PLANNING CONSULTATION RESPONSE

Application No	2025/1077
Proposal	Change of use from dwellinghouse (Class C3) to 4-bed 4-person HMO (Class C4) (Amended Description).
Address	329 Midland Road, Royston, Barnsley, S71 4AZ
Date of Consultation Reply	05.01.26
Consultee	Stacey Fieldsend-Case Management Officer

Drawing SCHEME PROPOSAL  
EXISTING AND PROPOSED FLOOR LAYOUTS Drawing No. P.100

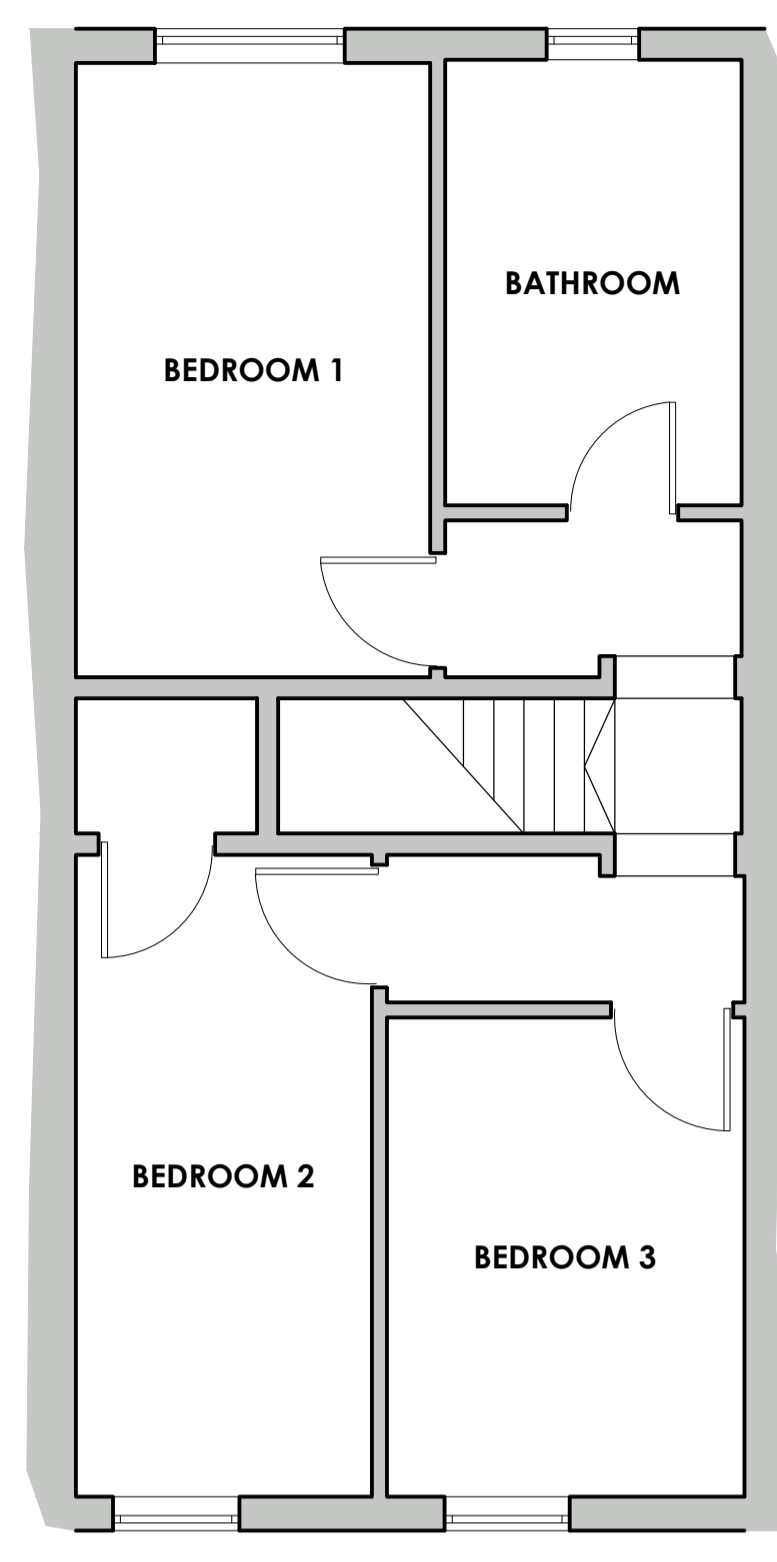
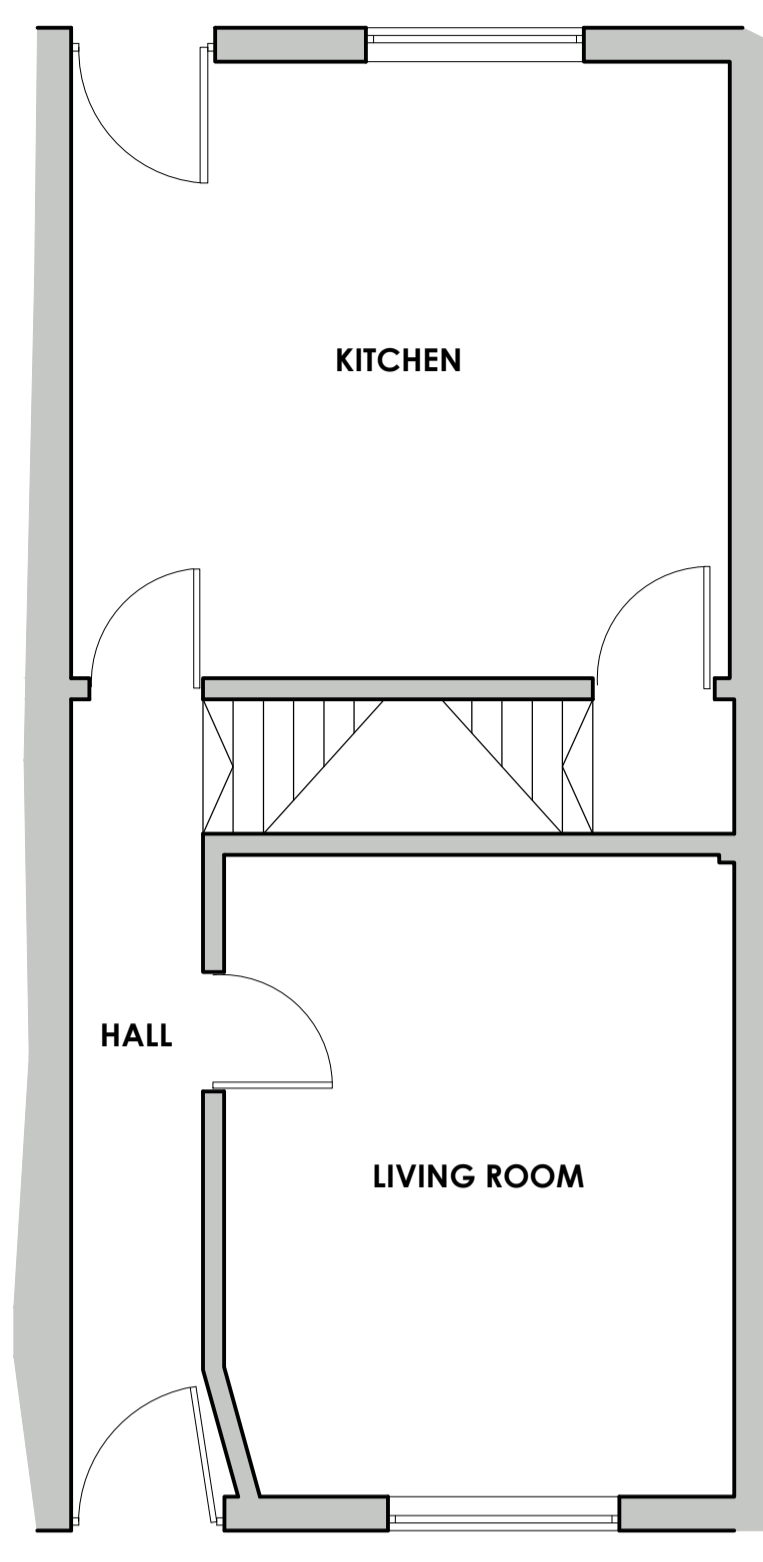
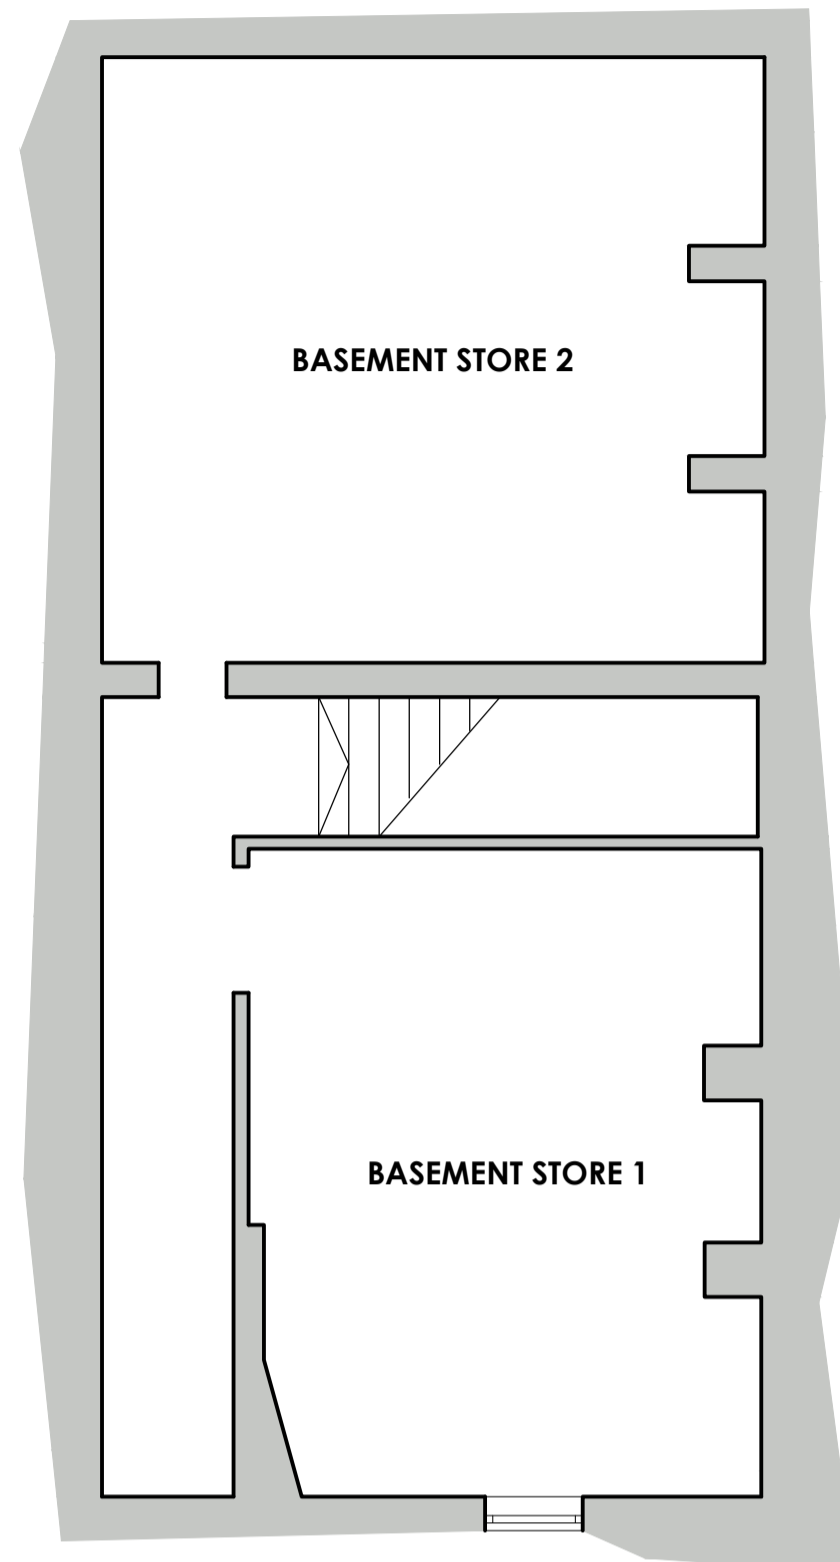
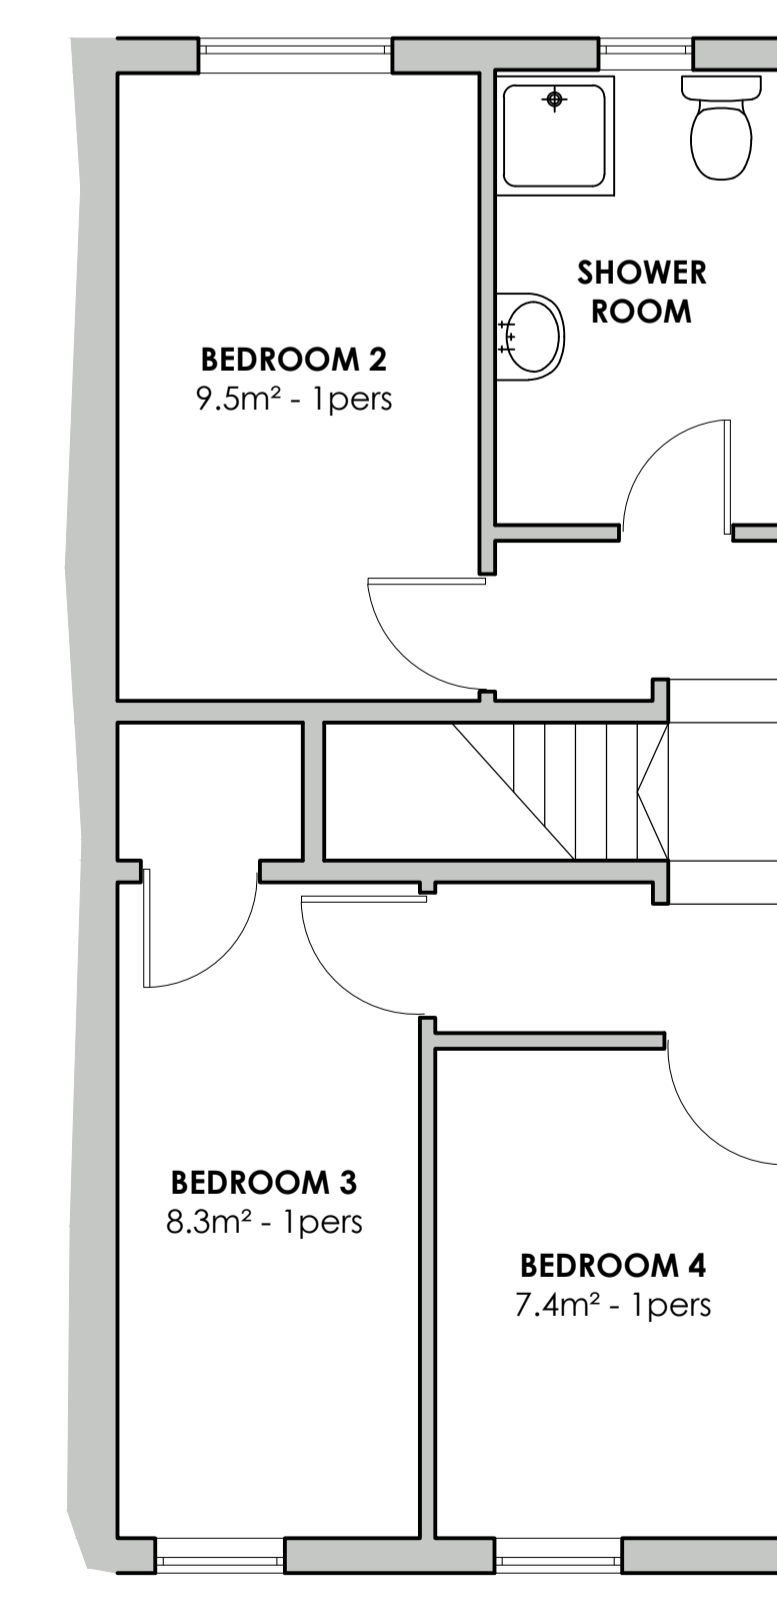
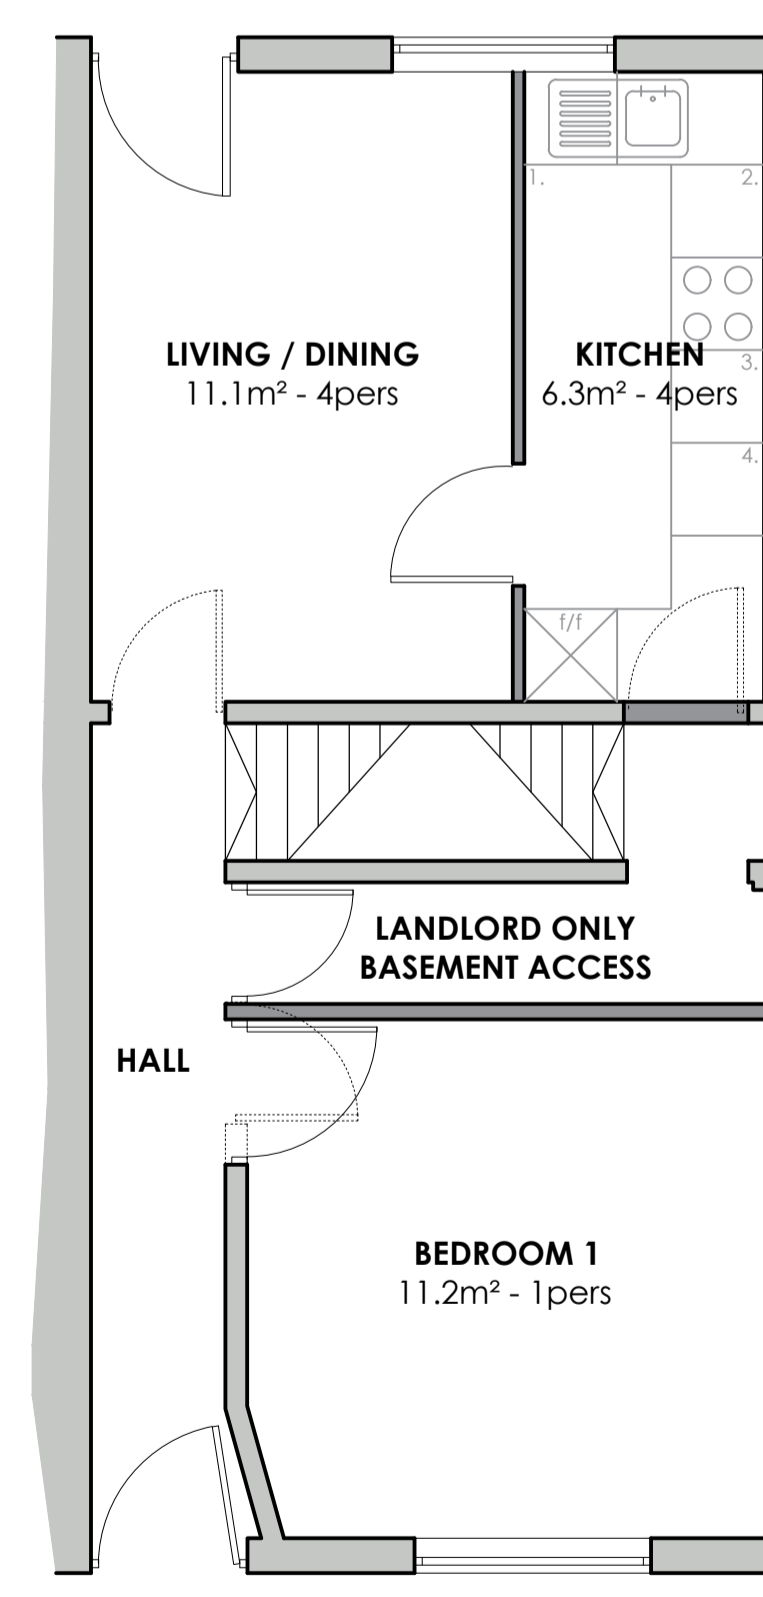
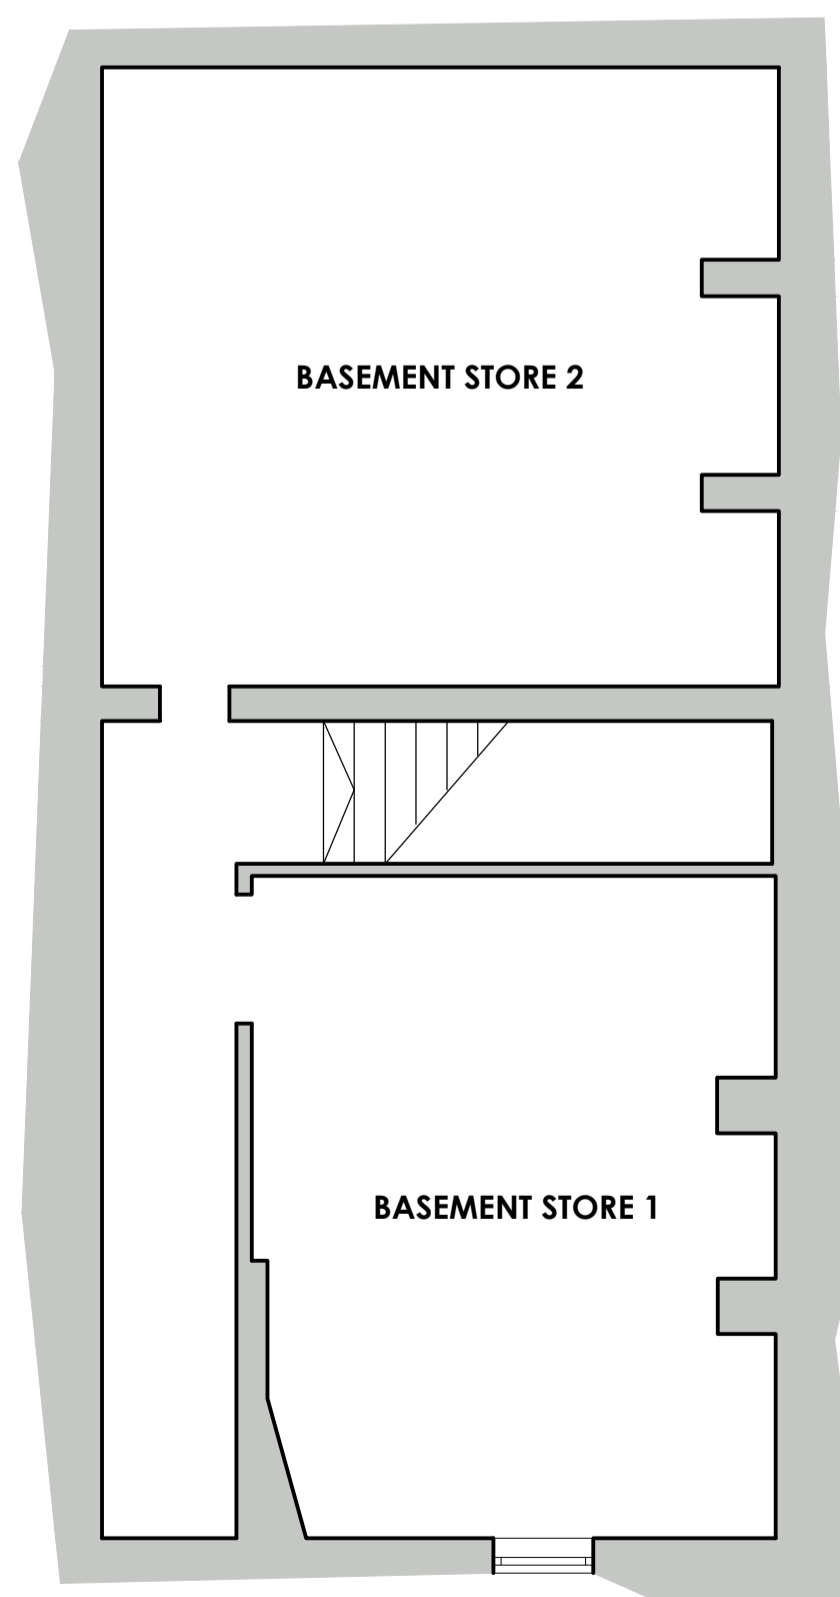
The bedrooms on the first floor are all under 10.22sq metres, therefore a **separate** living room will be required in addition to the kitchen/dining room. A combined kitchen/diner/living room does not qualify as communal living space.
